Phone: 0300 123 6780
Email: developeras@lancashire.gov.uk
Your ref: 03.2023.595
Our ref: 03.2023.595
Date: 11.10.2023

Planning Application No: 3/2023/0595

Proposal: Convert the existing garage into living accommodation, including addition of monopitch roof.

Location: 12 Calder Avenue Billington BB7 9NQ

Proposed (I) Building Plans

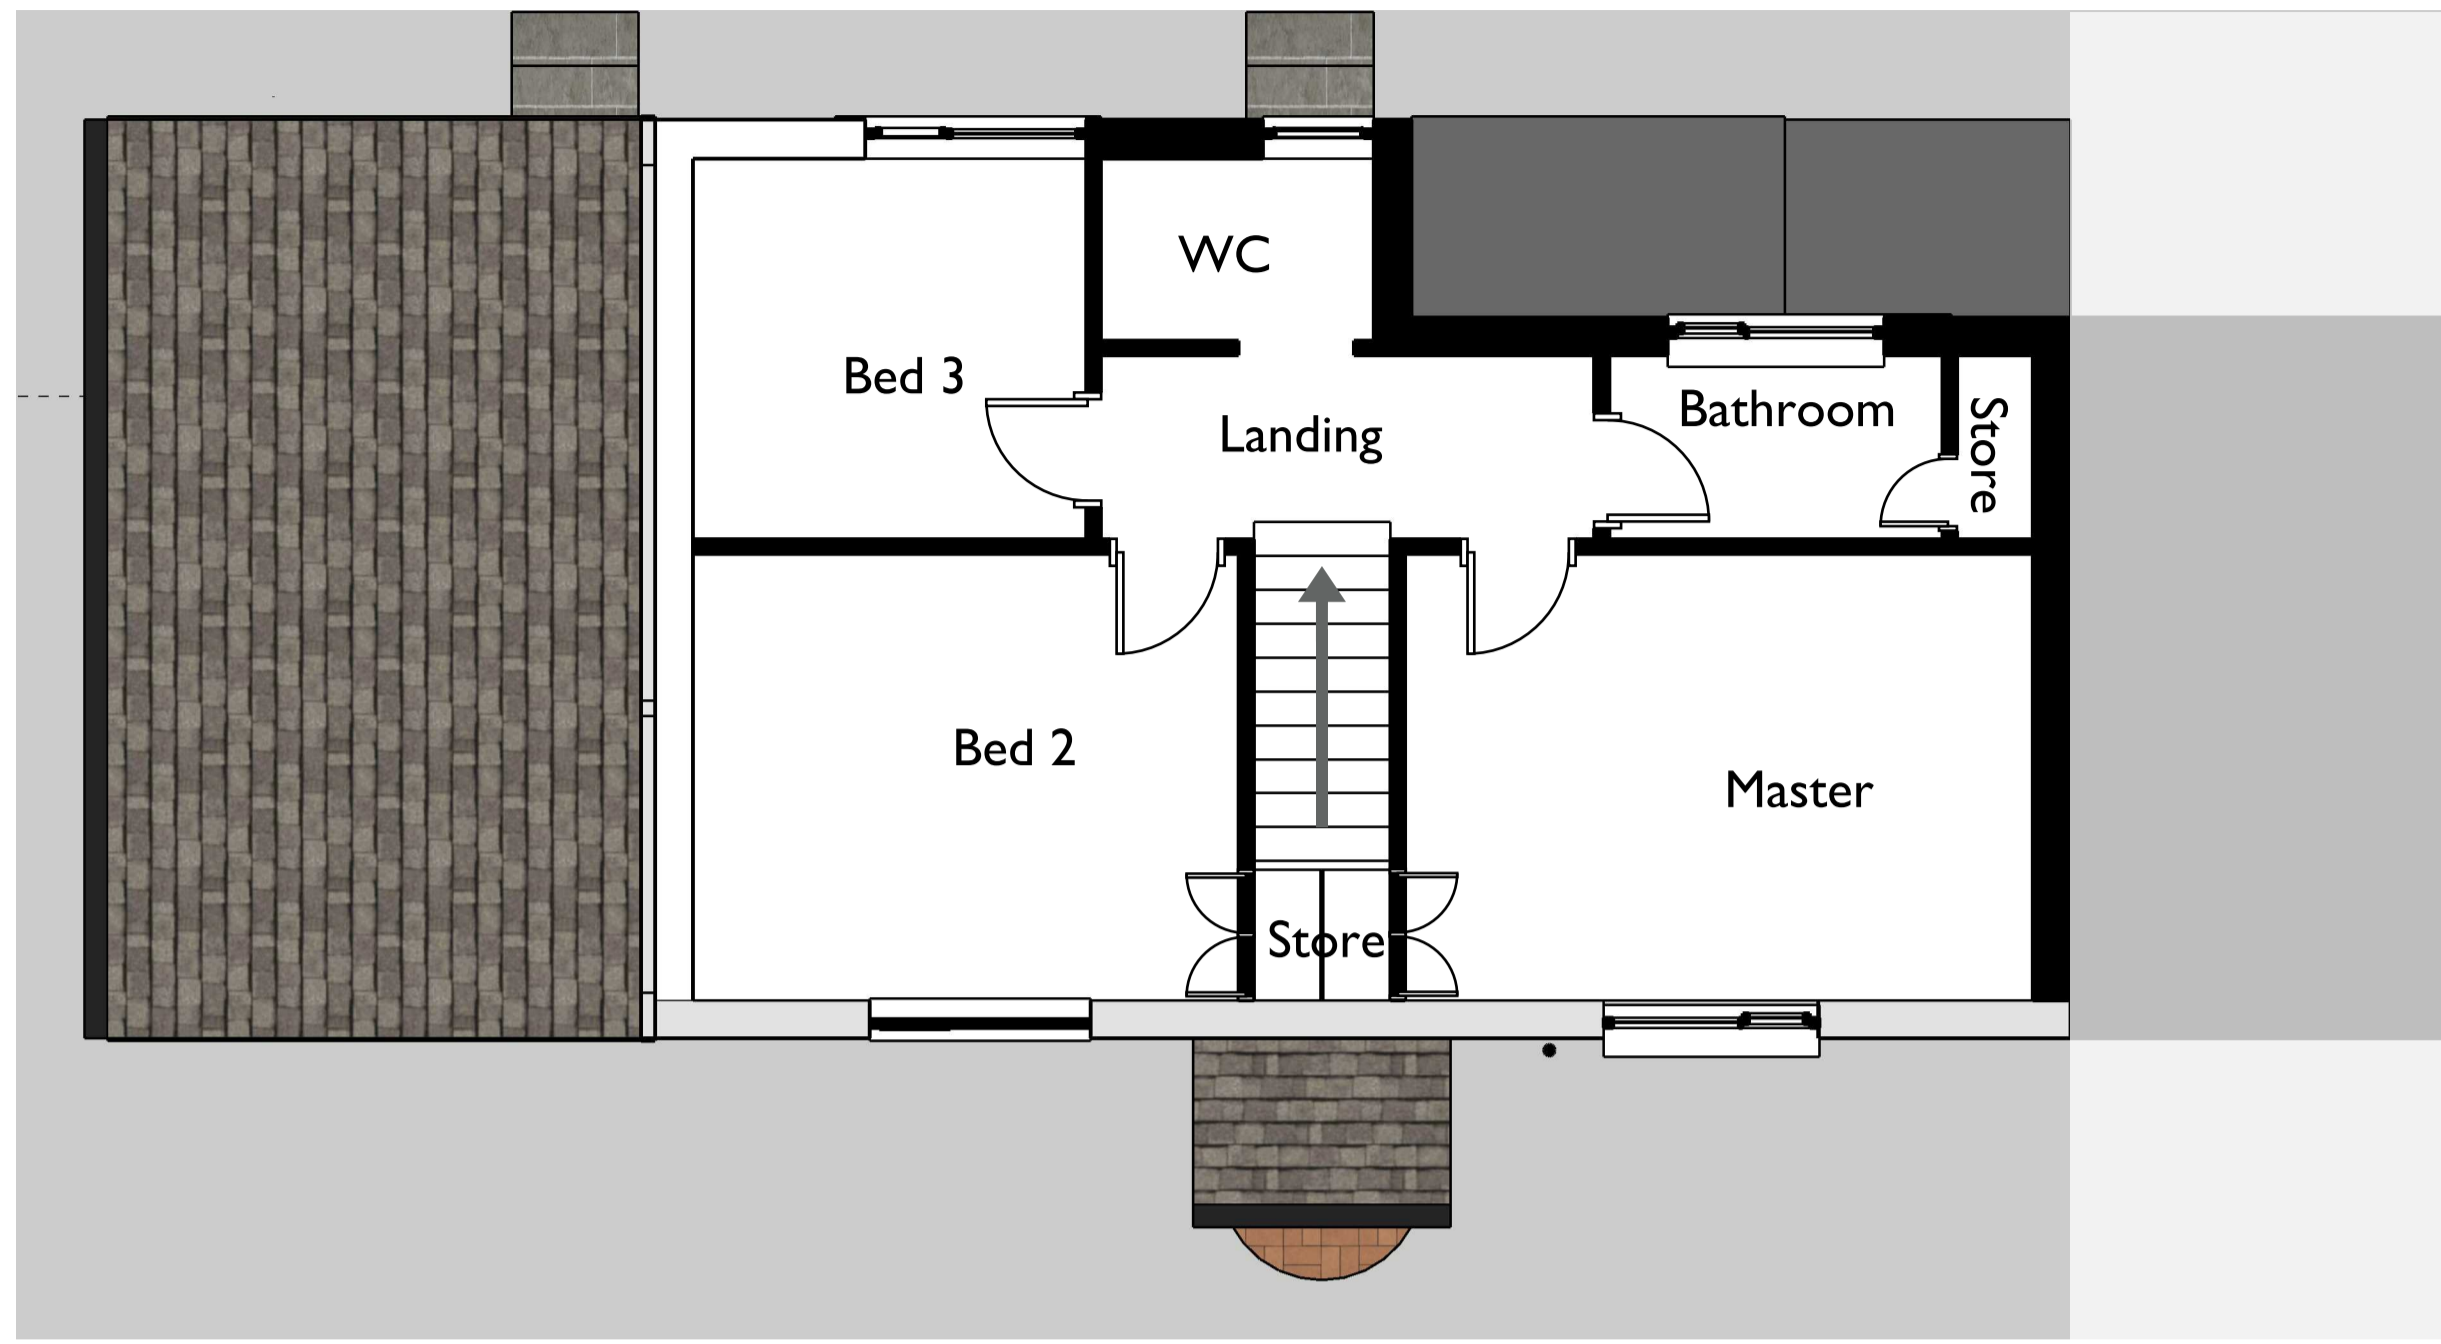
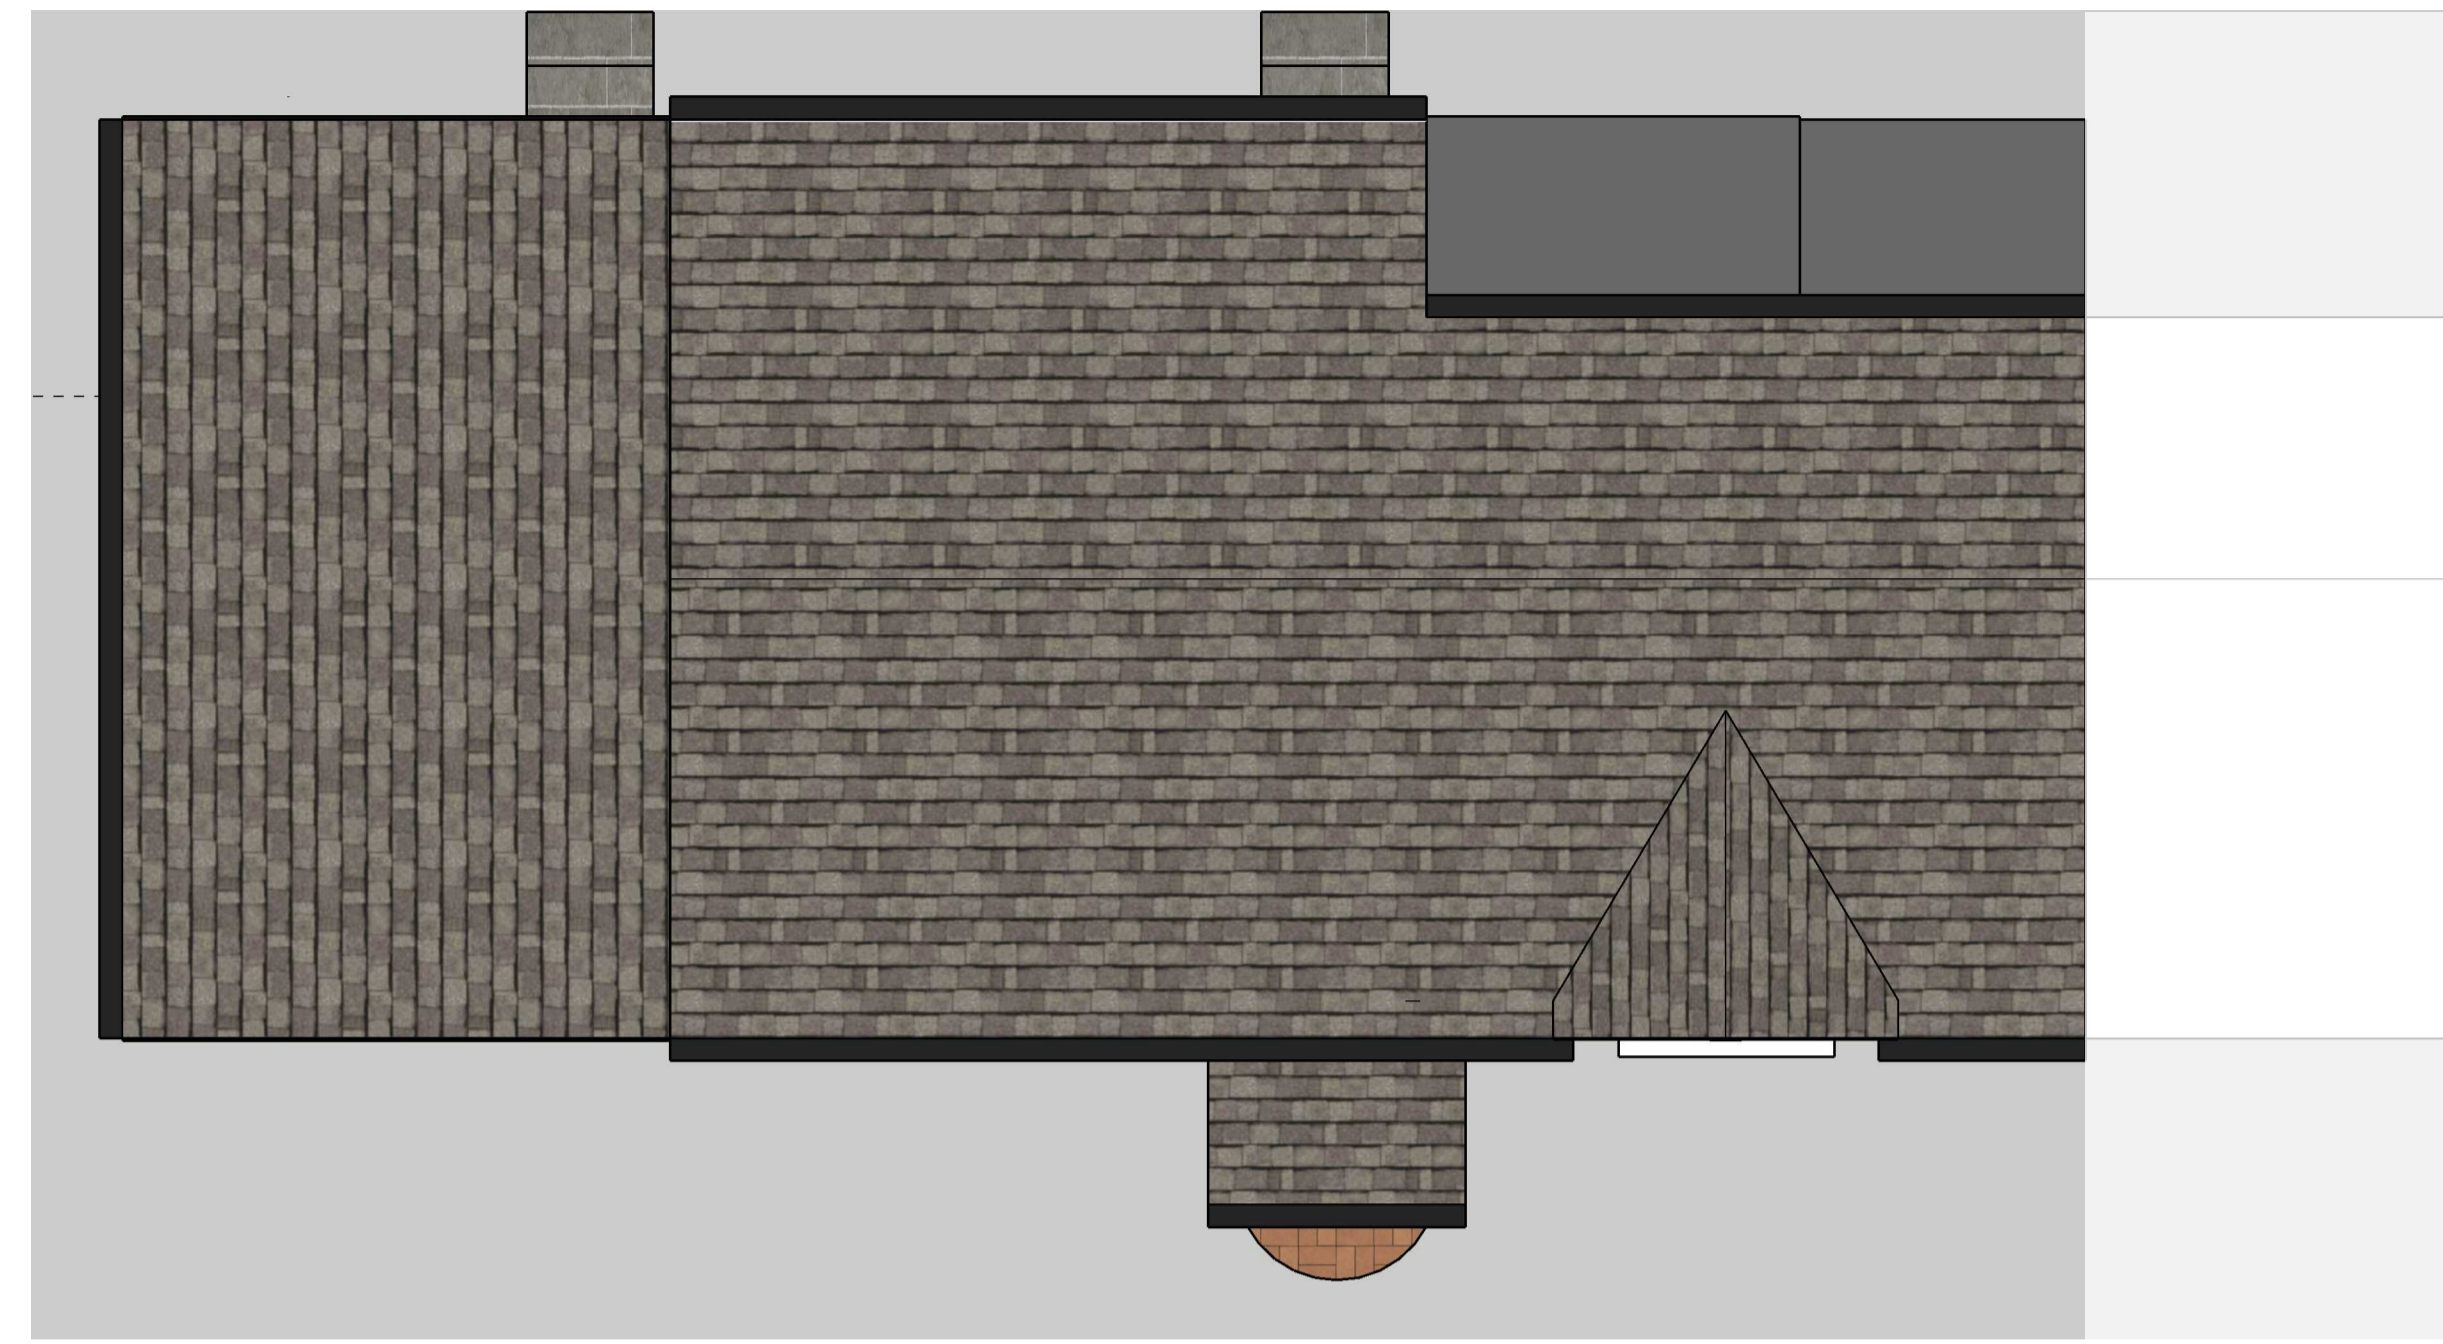
There is a loss of a parking space with this proposal. Providing 2 parking spaces can be provided within the curtilage as required by parking standards for this size of proposal then there is no objection to the proposal. The highway authority is of the opinion that the proposed development will not have a significant impact on highway safety, capacity or amenity in the immediate vicinity of the site.

- The parking areas must be constructed of a bound porous material and created before first occupation up until the lifetime of the dwellings existing in their proposed state. Reason: To ensure that satisfactory parking is provided before the dwelling hereby permitted becomes operative.
